F19/69

21 February 2019

**Parramatta Leagues Club Hotel (SSD 8800) - 1 Eels Place, Parramatta**

## ATTACHMENT 1

1 COACH - VEHICLE ENTERING
1:200

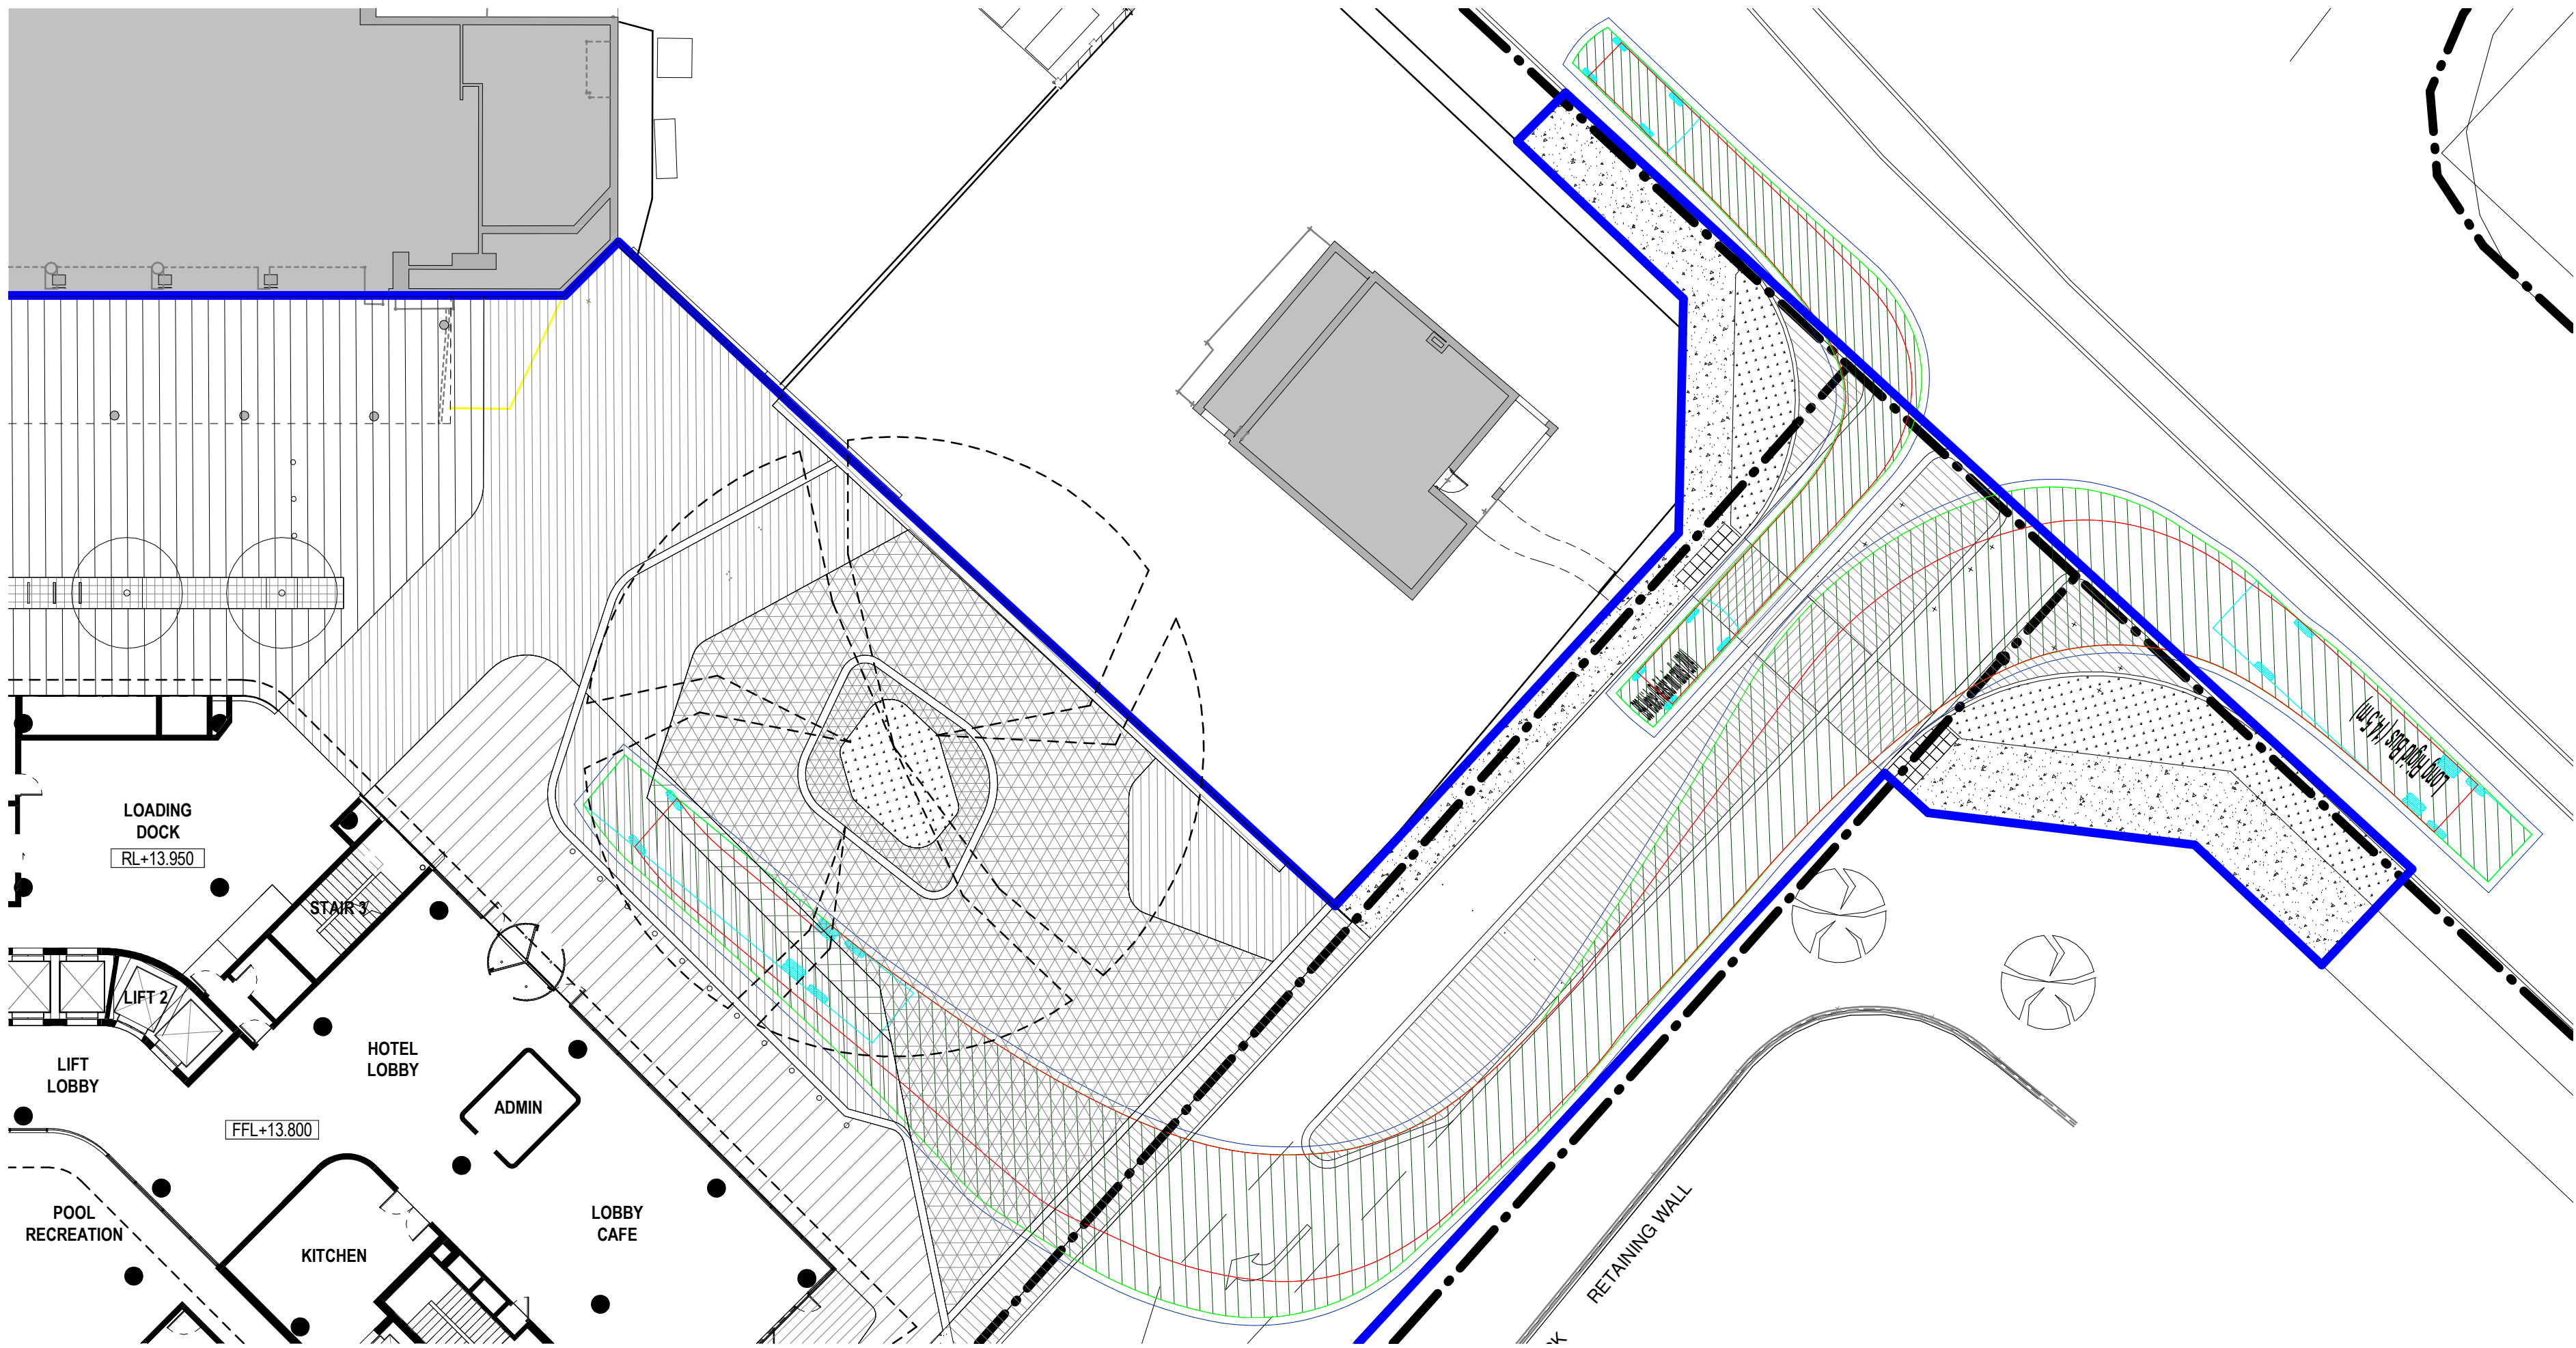
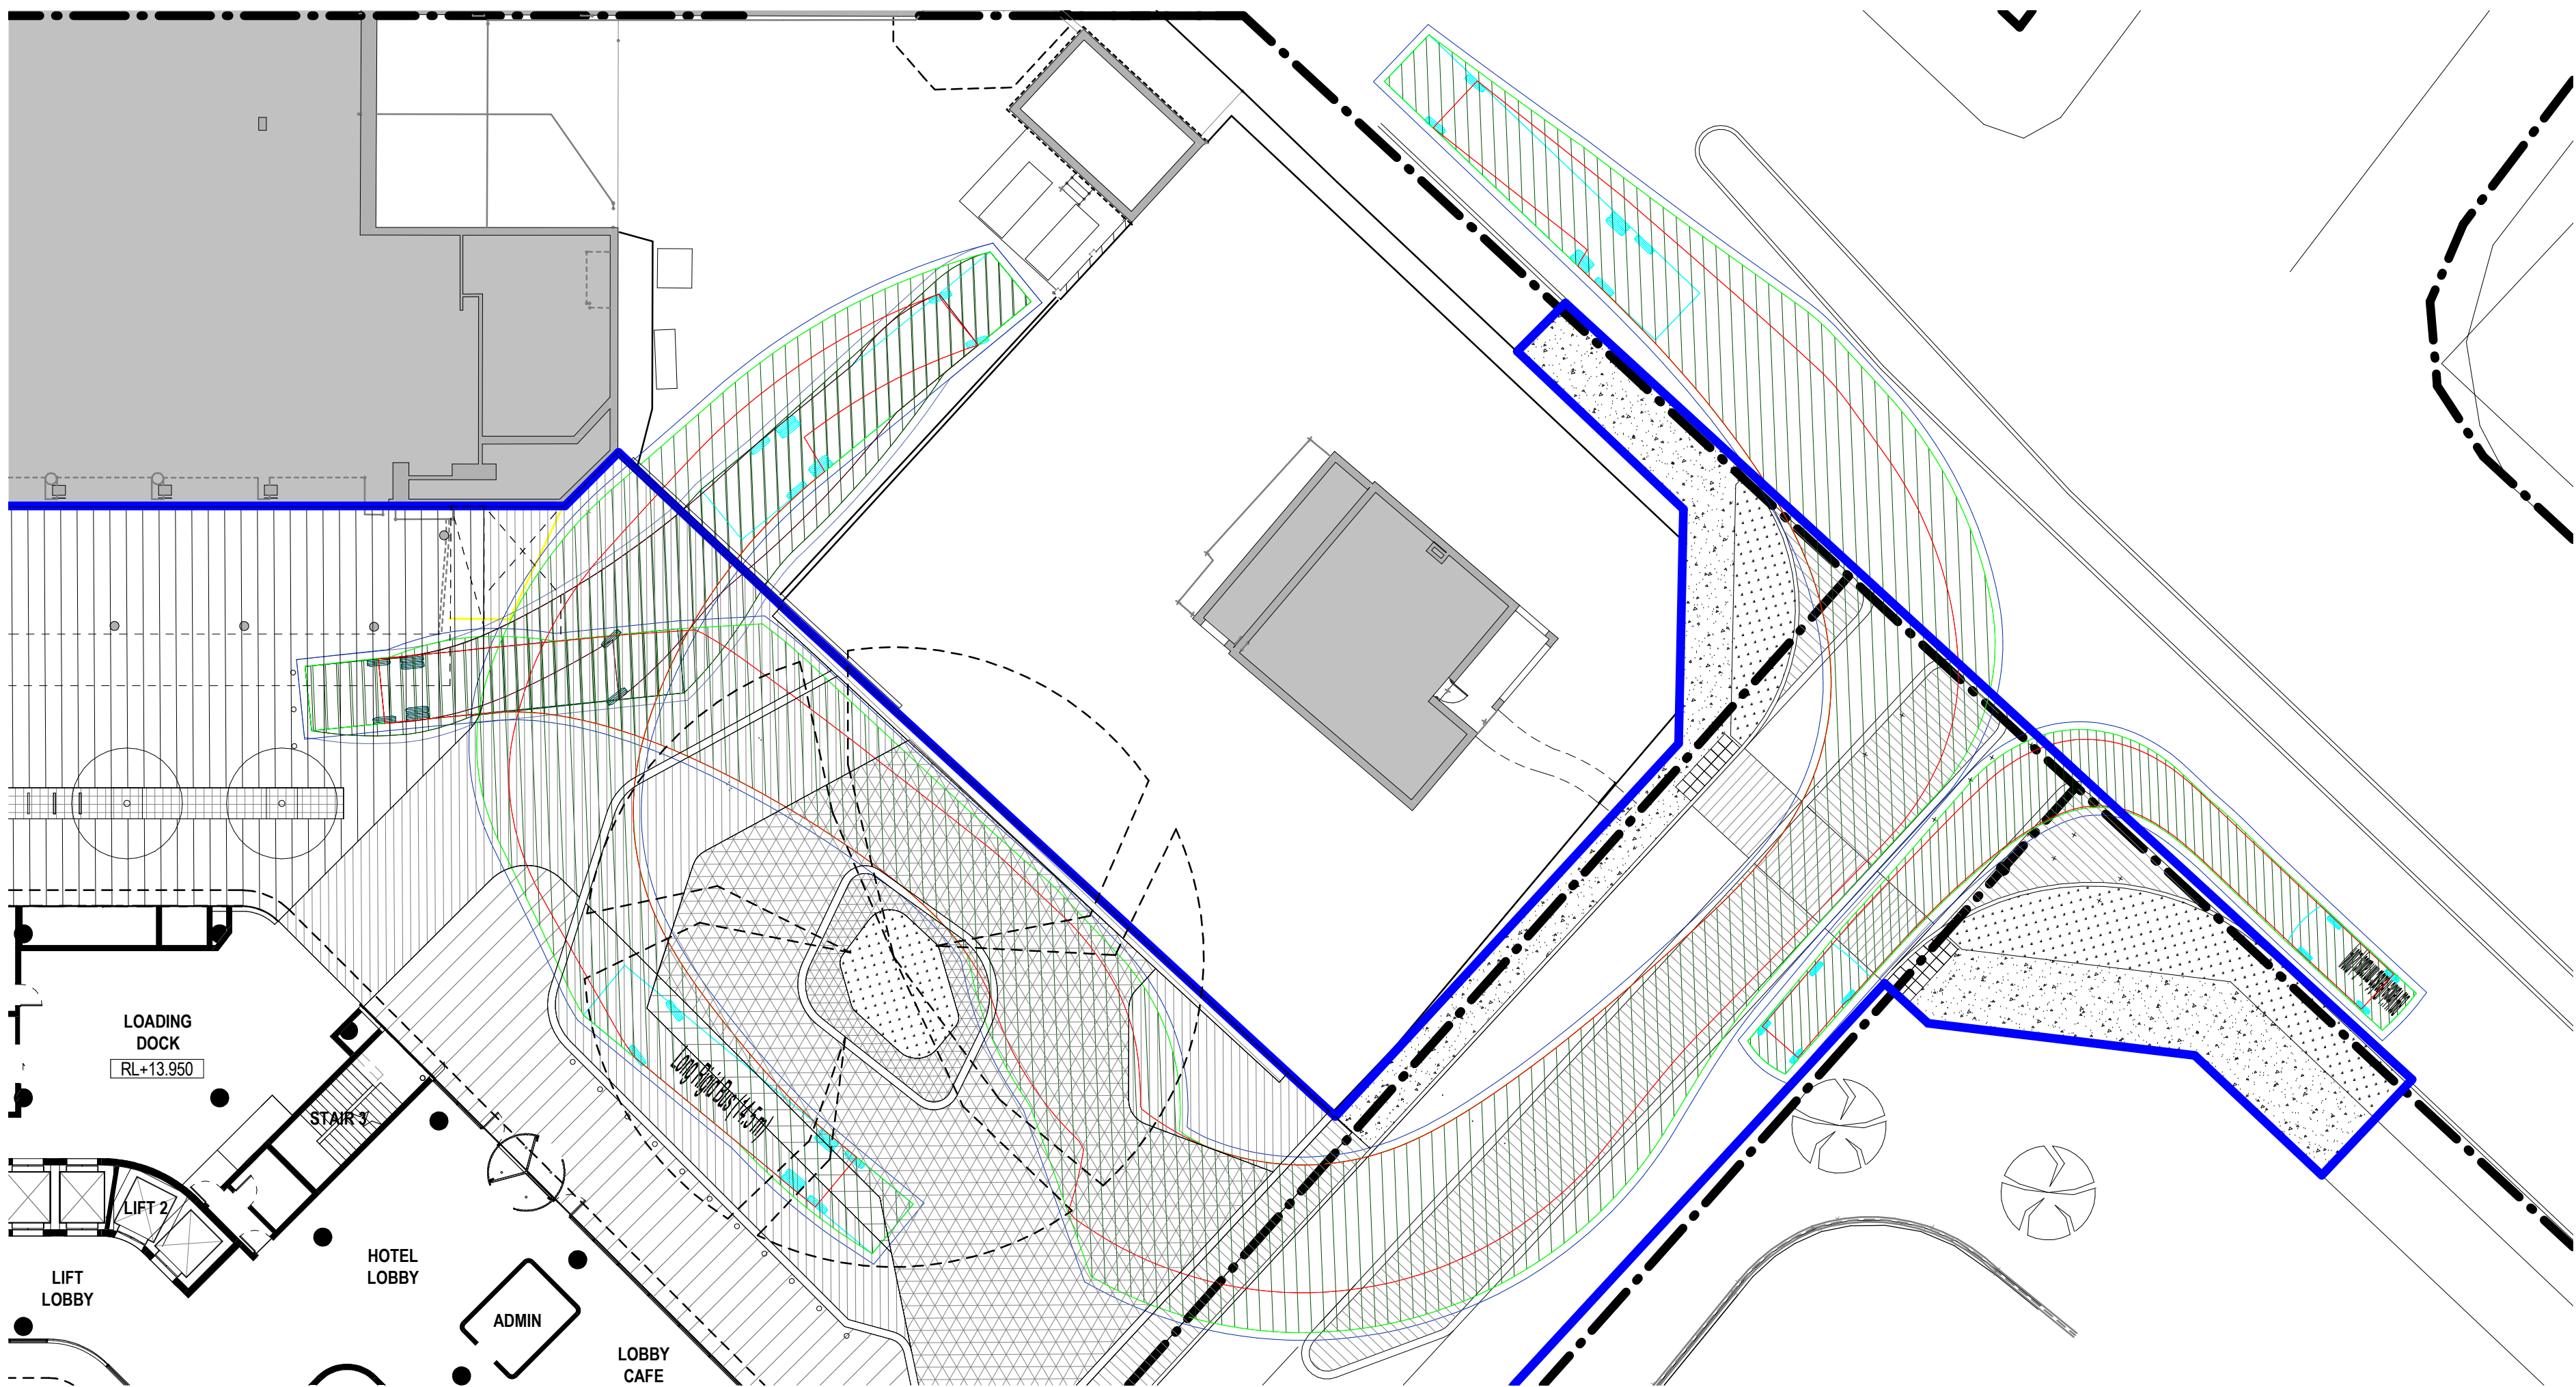
As is acknowledged in the Parramatta Leagues Club Hotel Development Application (DA), it is currently the intent that the access road that leads from O'Connell Street to the Western Sydney Stadium Northern Car Park is Venues NSW land and is a critical part of the operations of the Stadium.

However, SSD 8800 proposes that this road is used for vehicular access to the Hotel:

***Access at all times is critical and should not be comprised by introducing traffic from hotel clients and service providers. Any utilisation of that road for activities not related to stadium event bump in/out and during events that will cater for up to 30,000 patrons is simply not feasible.***

With more than one event per week on average, attracting between 15,000 and 30,000 patrons each, in addition to a significant calendar of non-event day functions, Venues NSW do not believe it is possible for the Northern Car Park Access Road to facilitate the additional traffic generated by any use for Hotel operations.

It is the view of Venues NSW that **all access** for hotel guests, tenants, staff and service providers be via Eels Place and that the Northern Car Park Access Road is preserved exclusively for the Stadium and associated uses.

Venues NSW strongly objects to the DA proceeding on the basis of any proposed use of the Northern Car Park access road.

The PLC's plans are re-drafted on the basis of all Hotel traffic entering and leaving exclusively via Eels Place.
